Project Location
Fountain Valley School
6155 Fountain Valley School Road
Colorado Springs, Colorado

Overall Site with Proposed Facilities

Site Development Plan_v2-redline.pdf Markup Summary

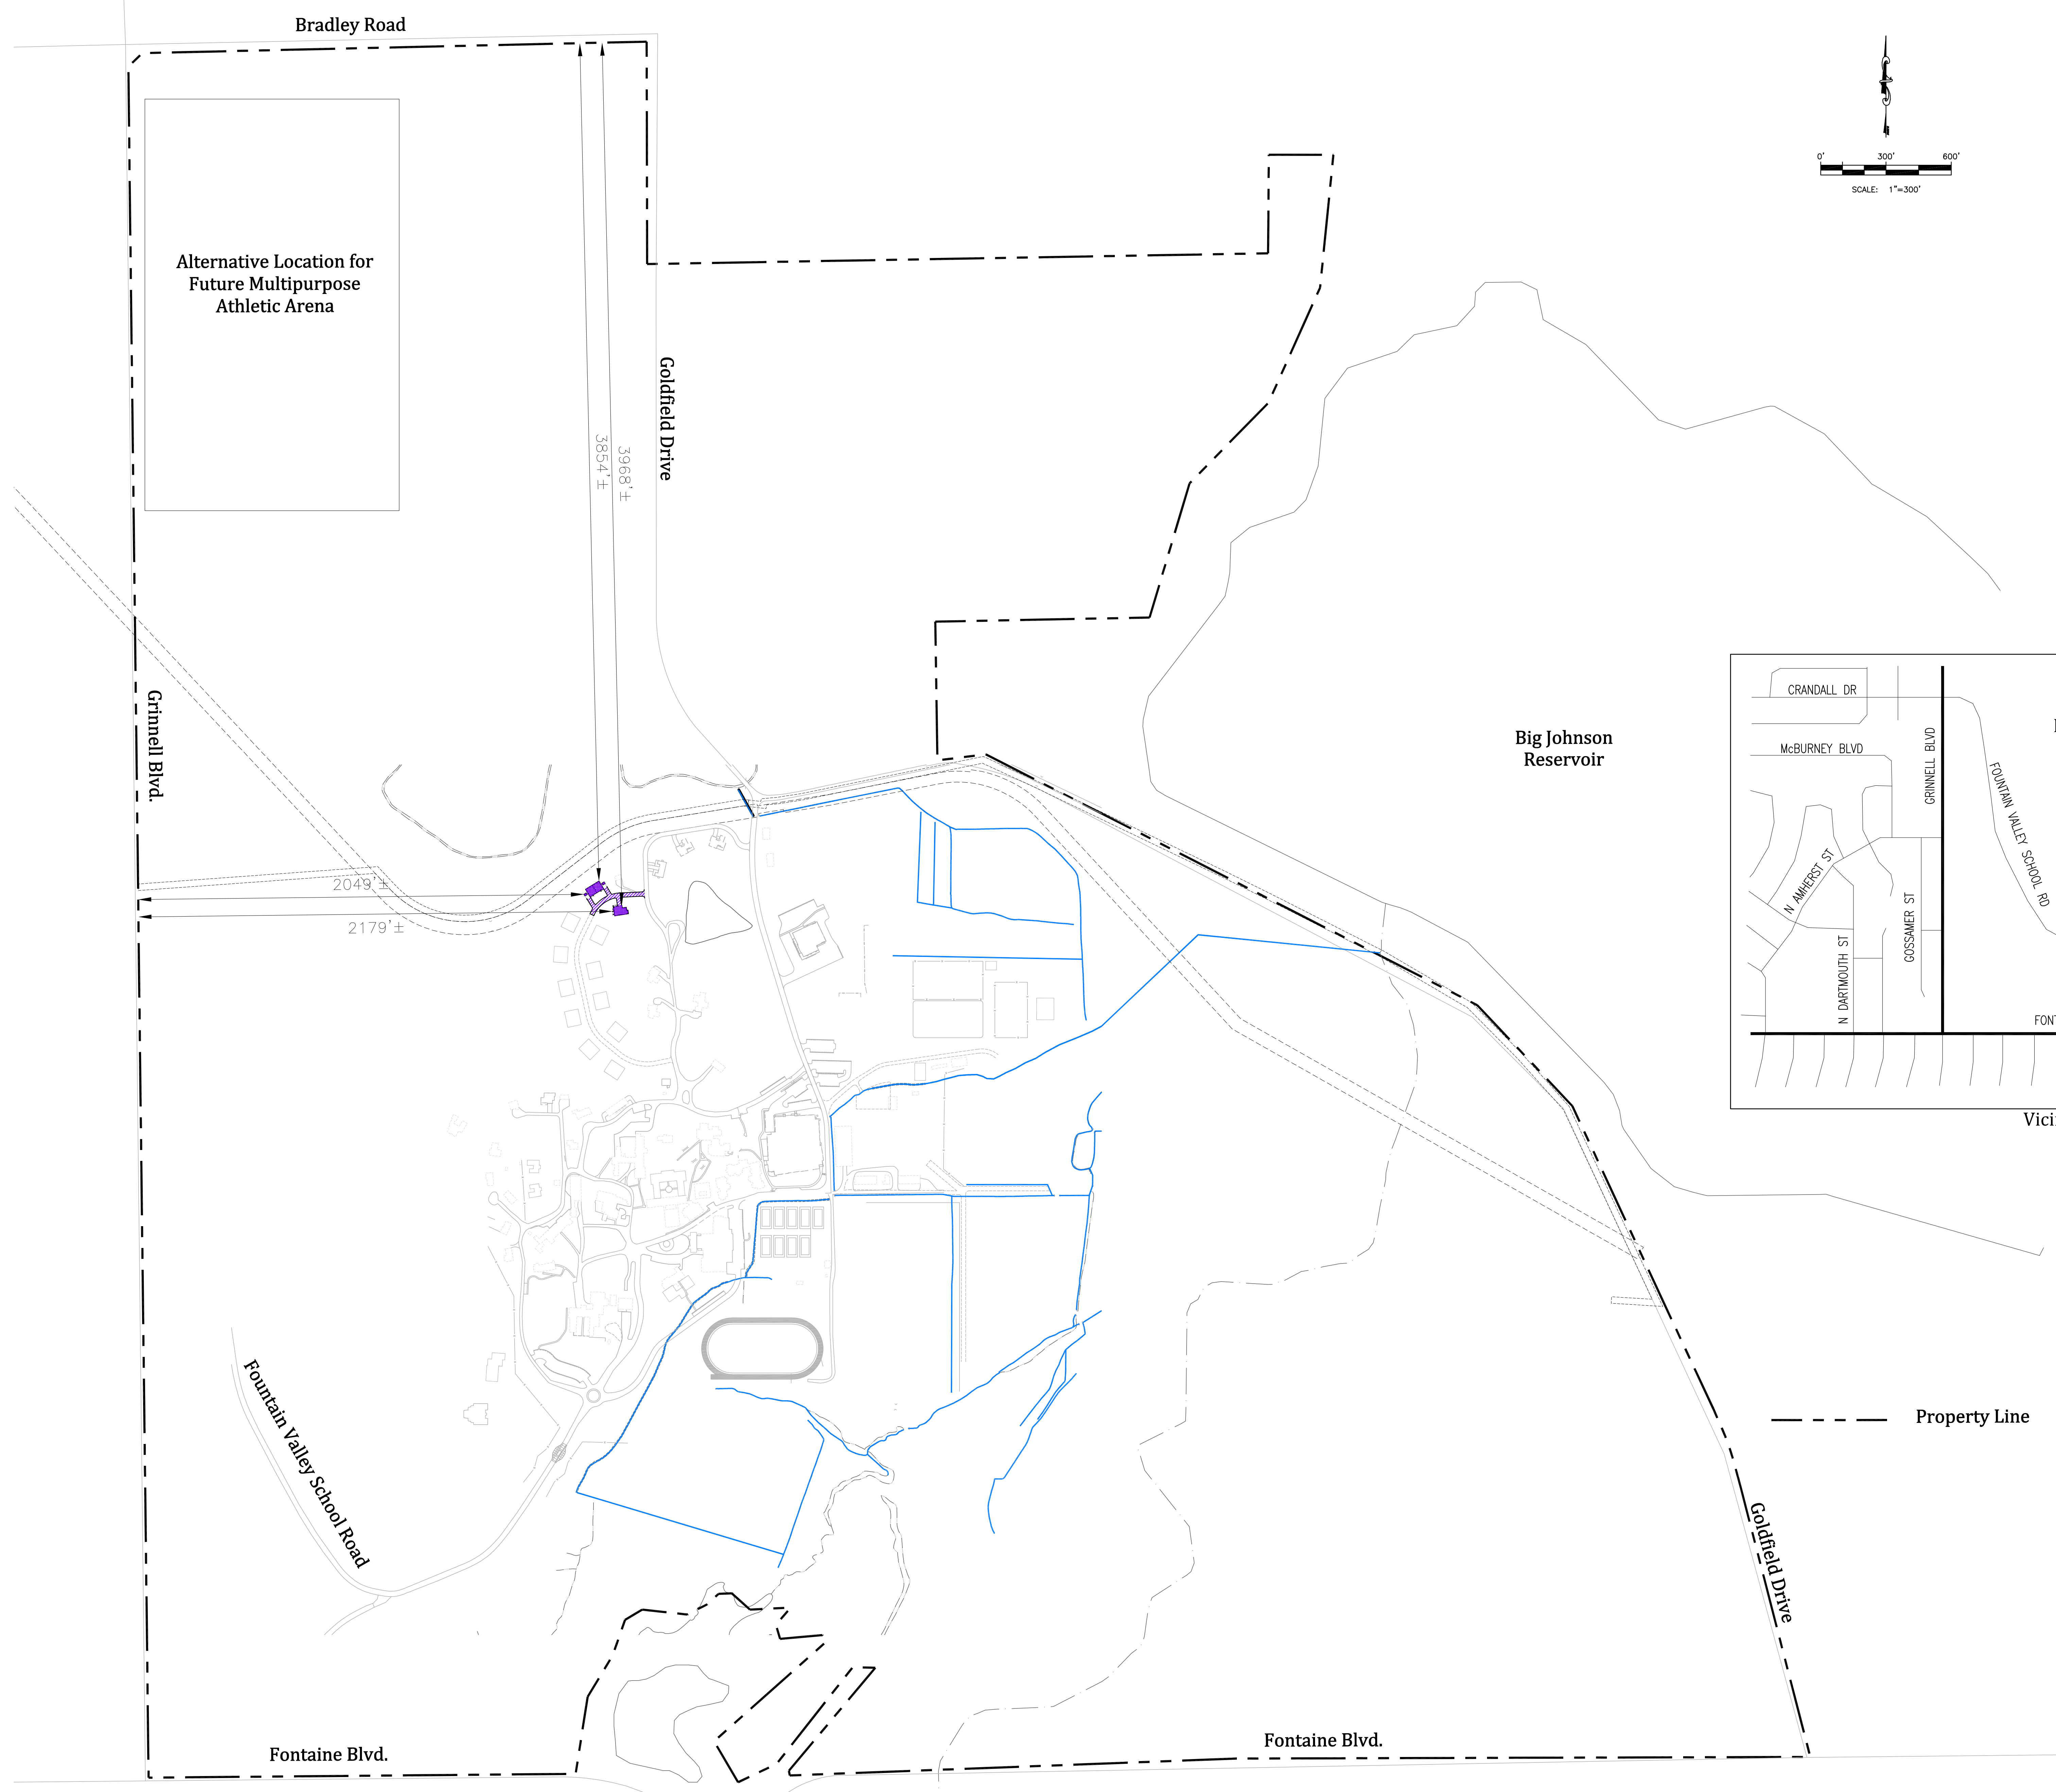
Review 1: Please label future roads Review 2: Unresolved (1)

Review 1: Please label future roads

Review 2: Unresolved
